REQUEST

Approximately 13.50 acres located at the northeast intersection of Albemarle Road and Novant Health Parkway, west of Cresswind Boulevard.

The petition proposes to allow up to 310 multi-family residential units on acreage developed with residential homes and vacant land, located just east of the intersection of Albemarle Road and Interstate 485.

TECHNICAL DATA SHEET
FOR
PETITION # 2022-066
ALBEMARLE ROAD APARTMENTS
CHARLOTTE, NORTH CAROLINA

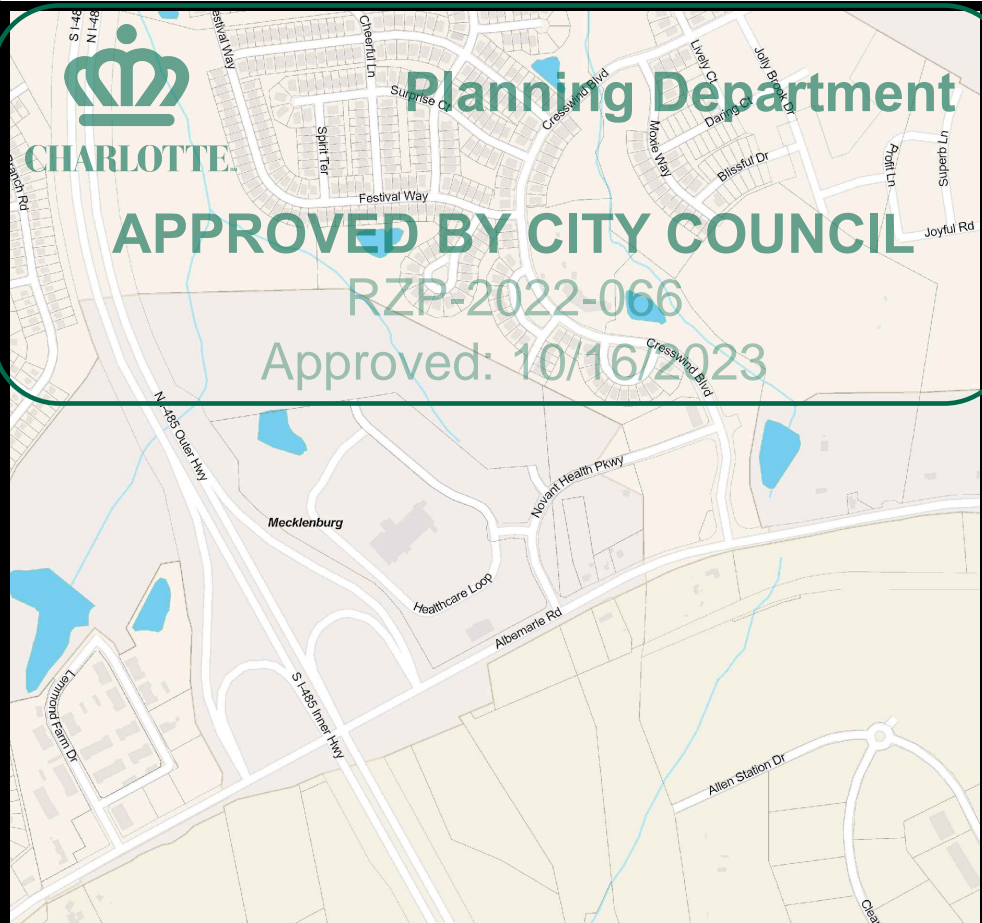
1. Revise site plan and conditional note(s) to commit to dedicate 100 feet of right-of-way or existing right-of-way, whichever is greater from the road centerline of Albemarle Road. The site plan shall label and dimension the right-of-way from the road centerline of Albemarle Road and Novant Health Parkway.

2. Tree save must meet all standards. Easements are not permitted in tree save areas. Remove this statement because it does not follow the ordinance.

ILLUSTRATIVE SITE PLAN
FOR
PETITION # 2022-066
ALBEMARLE ROAD APARTMENTS
CHARLOTTE, NORTH CAROLINA

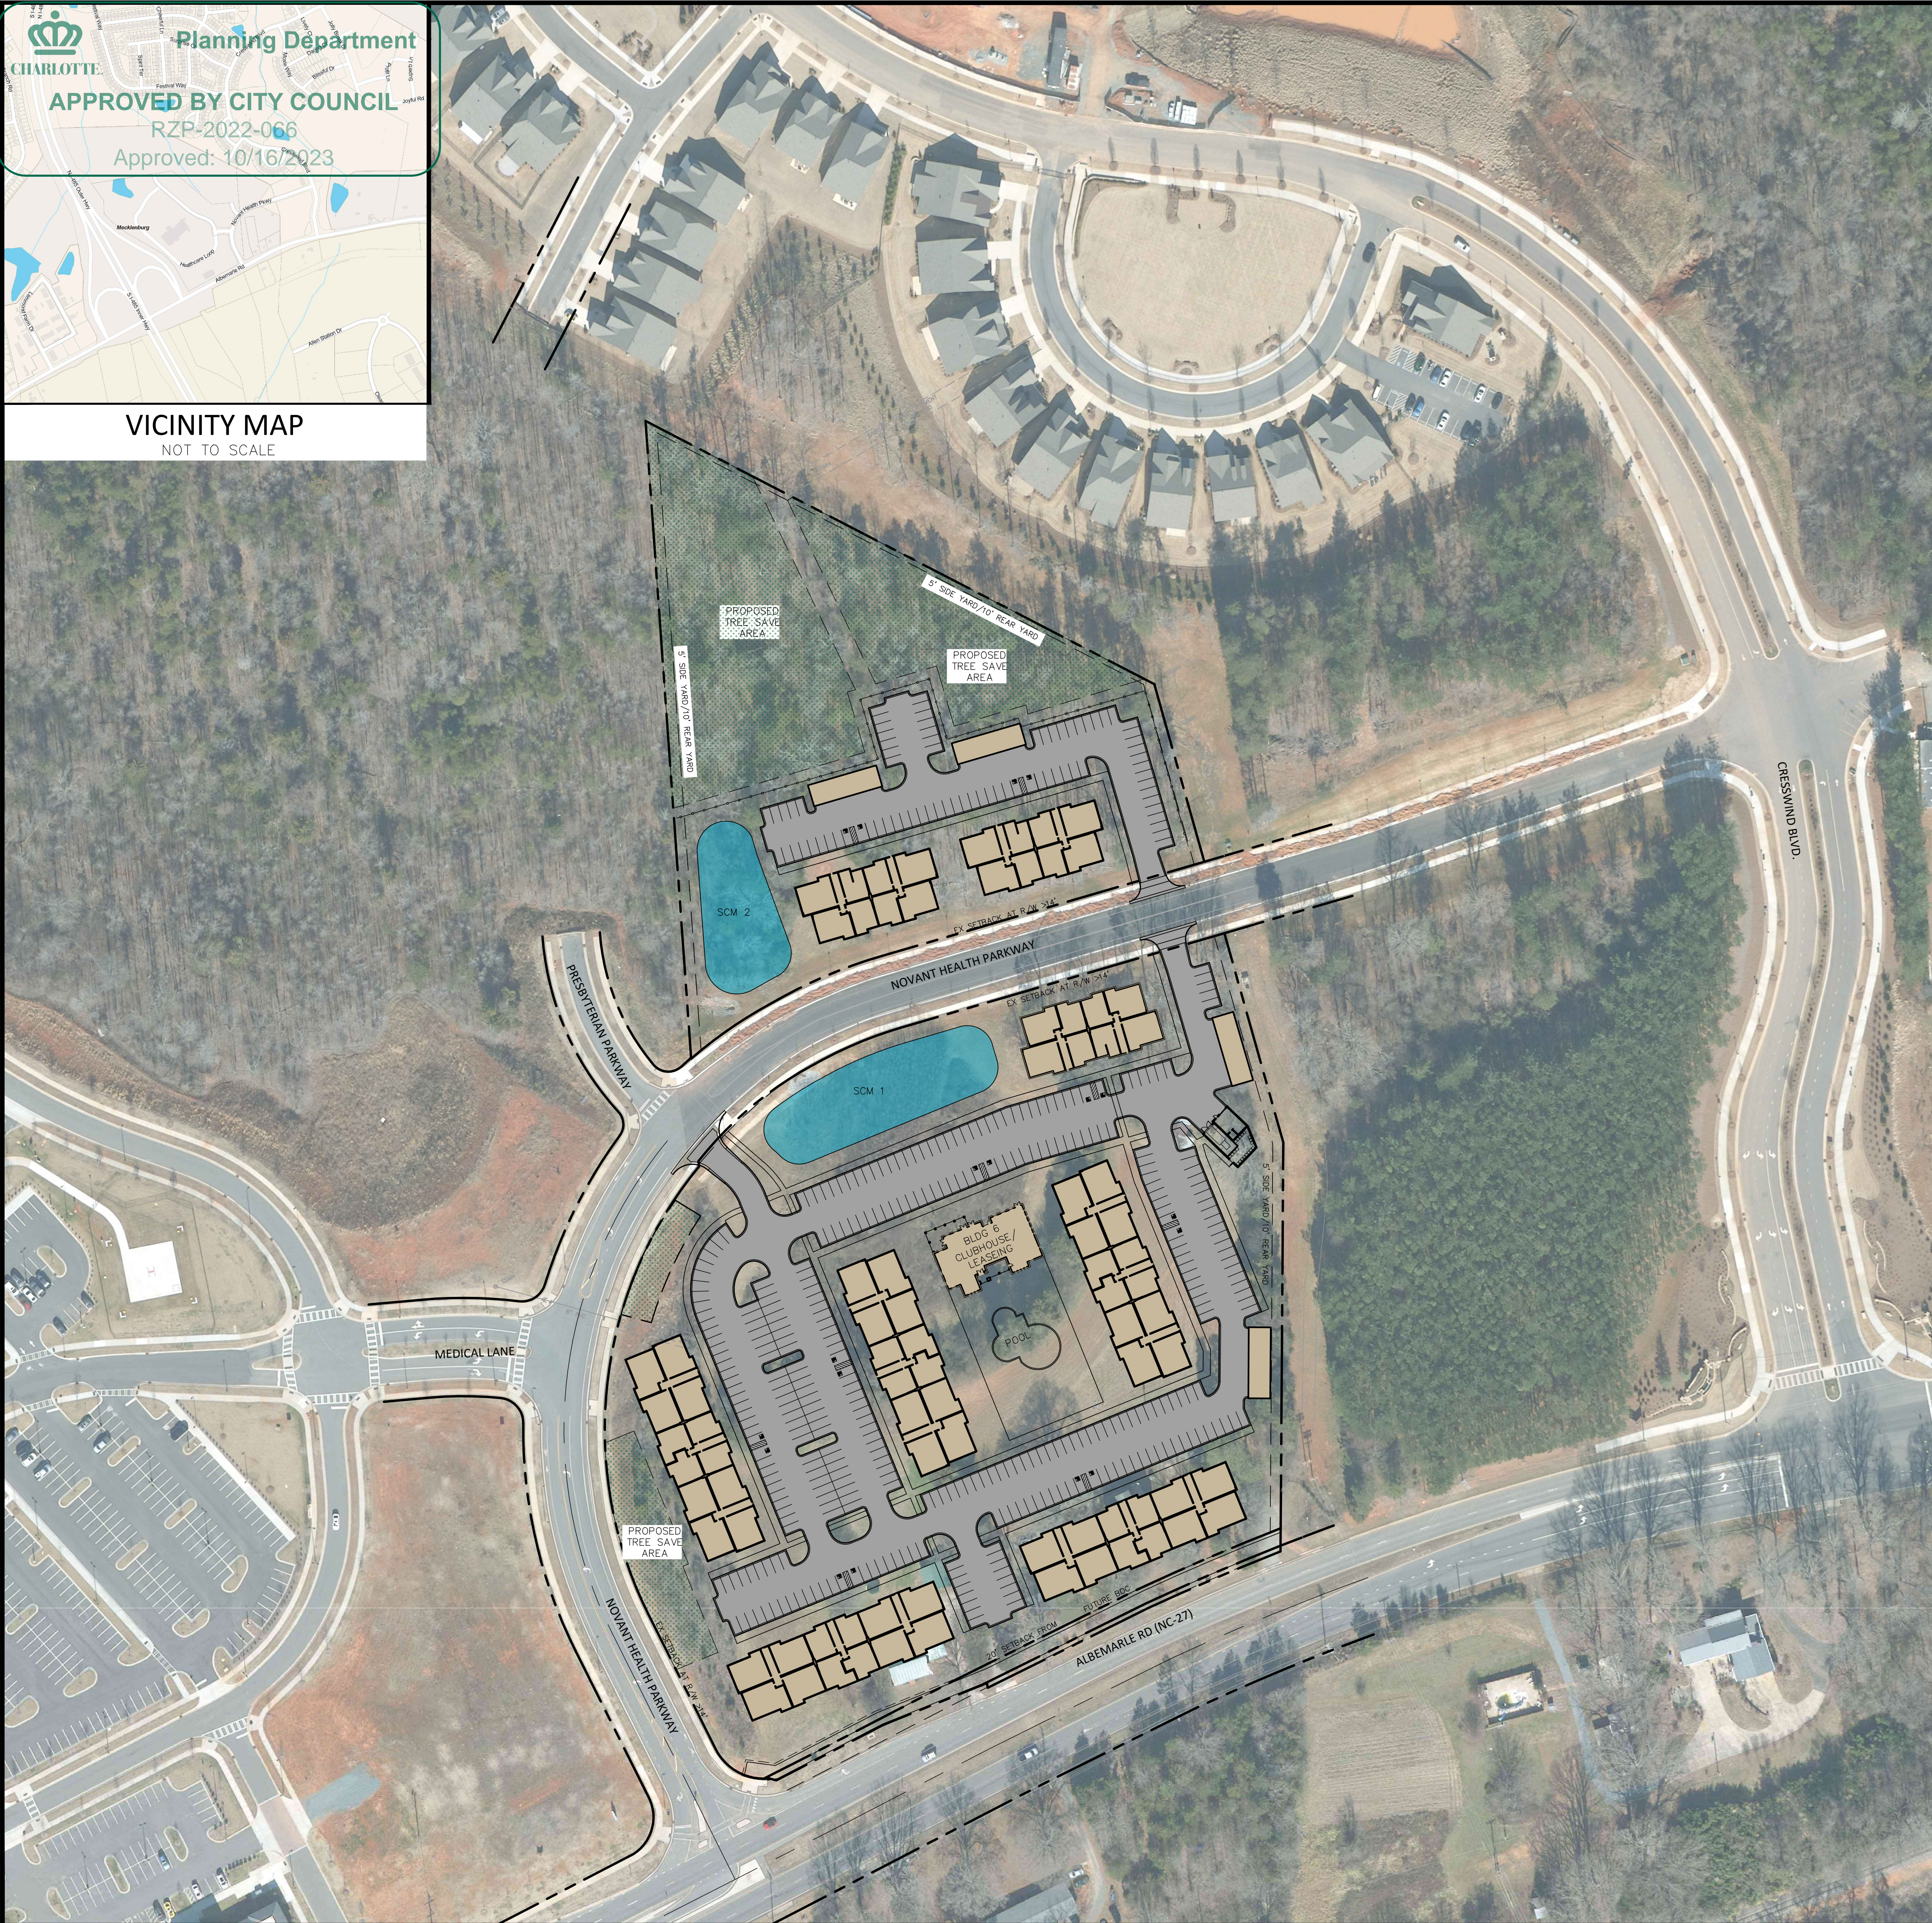
3. Confirm if the clubhouse is referenced/committed to in the development notes.
4. Possible BMP areas are located along Novant Health Parkway. Approved plant materials should be provided so the areas serve to add to community character.
